Appendix D – Detailed Response to Submissions

Table 1 DPHI Request for Information

Table 2 Agency Submissions

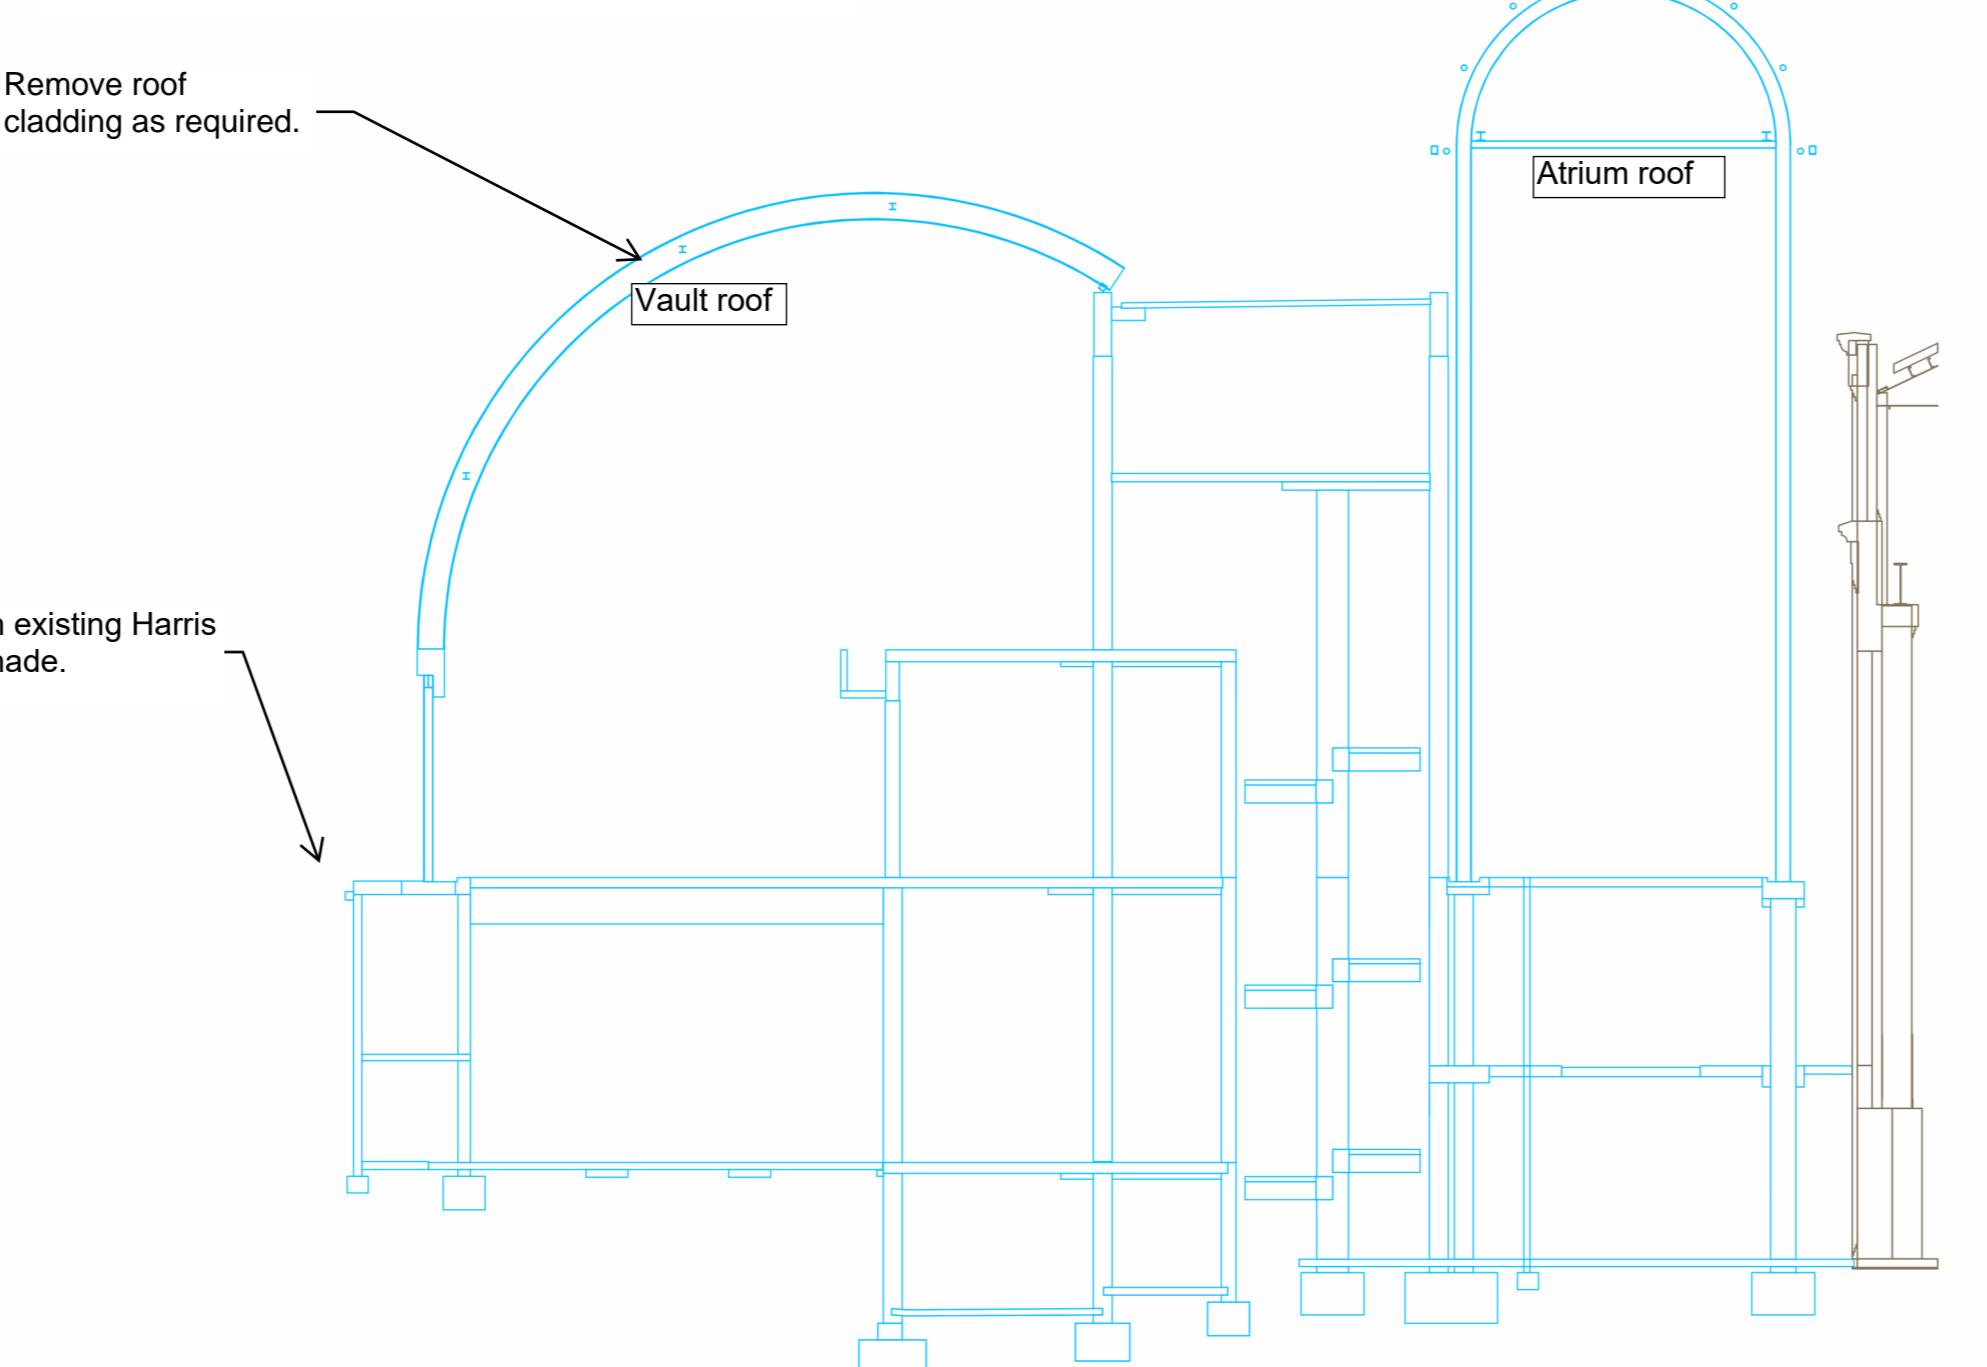
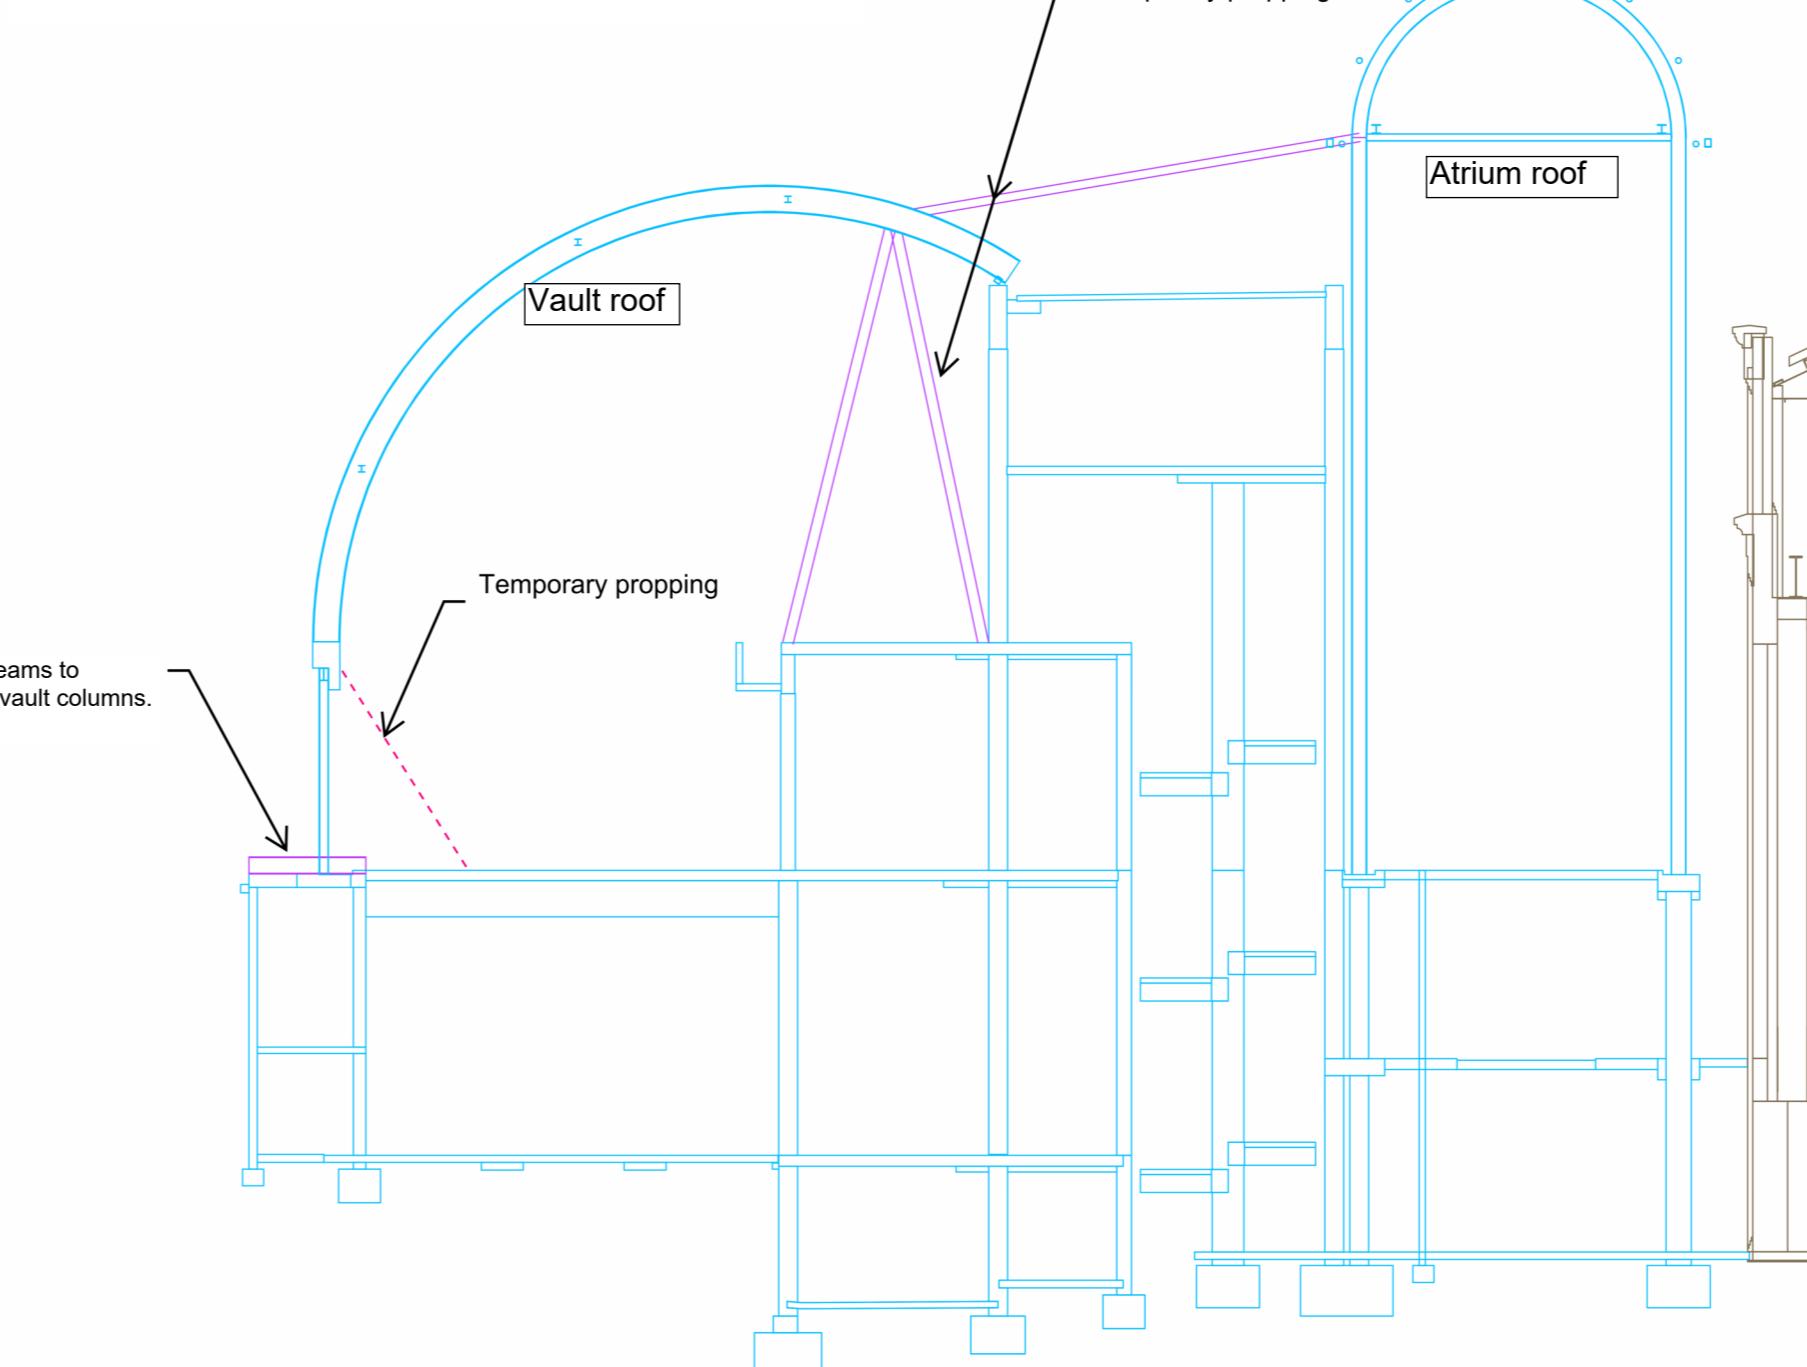
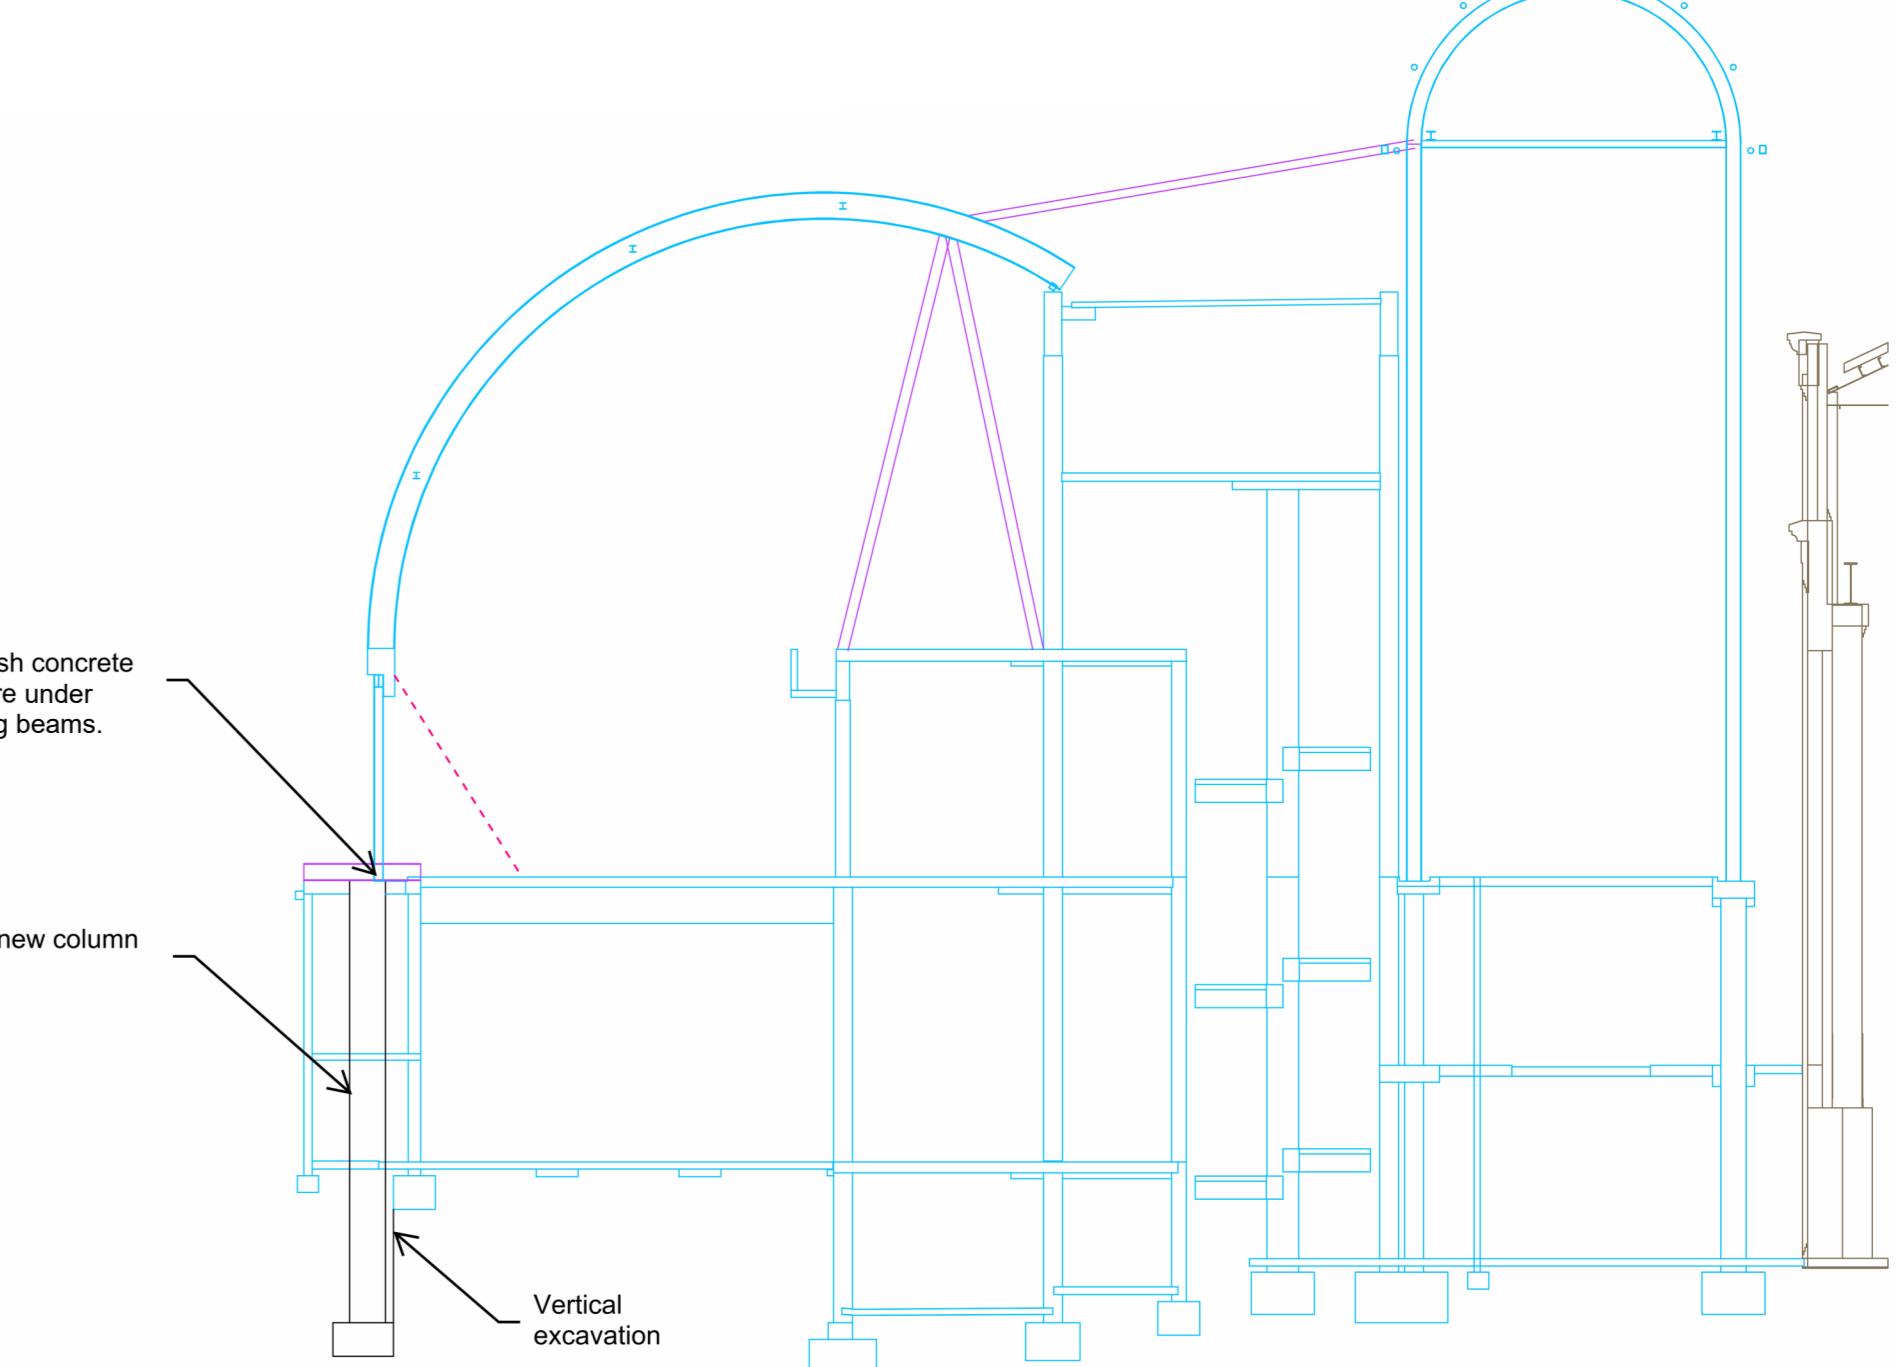
<ul style="list-style-type: none"> - Clarification is required as to whether the intent is to retain the existing roof form and structure and how this would be extended to complete the arch of the barrel. The materiality of the roof is also to be clarified with the continuing use of a high durable long life; lightweight metal roof preferred. Galvanic reactions between dissimilar metals must be avoided or managed. - The demolition of the lower-level colonnade associated with the Wran Hall allows creative industry spaces to be provided along and activate Harris Street. This is supported; however, the spaces would be disconnected from the Powerhouse Museum and servicing and waste removal needs to be further considered. 	<p>finishes. In relation to heritage impact, the amended HIS provides further assessment of these materials.</p> <ul style="list-style-type: none"> • Refer to Amended Design Report at Appendix F. • Servicing of the Creative Industries spaces will need to occur from the Harris Street frontage. The waste servicing requirements for the users of this space will be extremely low and comparable to a typical office use. Emptying of waste would occur on a daily basis by each tenant taking waste to the central waste room within the loading dock. It is expected that each tenancy will be provided with a 10L bin. • Waste reduction initiatives as part of the submitted ESD Report at Appendix BB of the EIS include a commitment to 80% of construction and demolition waste to be recycled by the head contractor.

CoS10	<ul style="list-style-type: none"> • Materials and Building Expression <ul style="list-style-type: none"> - There is only a very limited palette of materials shown on the architectural drawing set - The design report also includes garden mesh and aluminium cladding - The design report also references 'The new built form will be comprised of a mix of recycled and new bricks, brick slips, stone, ceramics, glass, metal cladding and class 2 in situ concrete and precast concrete.' - The proposed materials and finishes need to be further clarified and the drawings should be amended to clarify materials and key these to the elevations and sections. This is also requested to assist in assessing the potential heritage impacts of the additions. - The design of the Wran hall and galleria adaption is generally supported; however, more information is required to understand the amount of demolition and retention of structure. - The northern and southern ends of the Wran hall and the galleria are shown in elevations as brick. More information is required regarding the construction and structural delivery of brick ends to the existing steel super structure. The roof skin is also to be clarified, it is unclear from the renders, what this is intended to be. 	<ul style="list-style-type: none"> • The Amended Design Report at Appendix F to this Submissions and Amendments Report provides further details on the proposed materials and finishes. In relation to heritage impact, the Amended HIS (Appendix L) provides further assessment of these materials. Details regarding the extent of demolition of internal areas within the Wran Building are included within the Structural Sequencing diagrams contained at Appendix H to this Submissions Report.
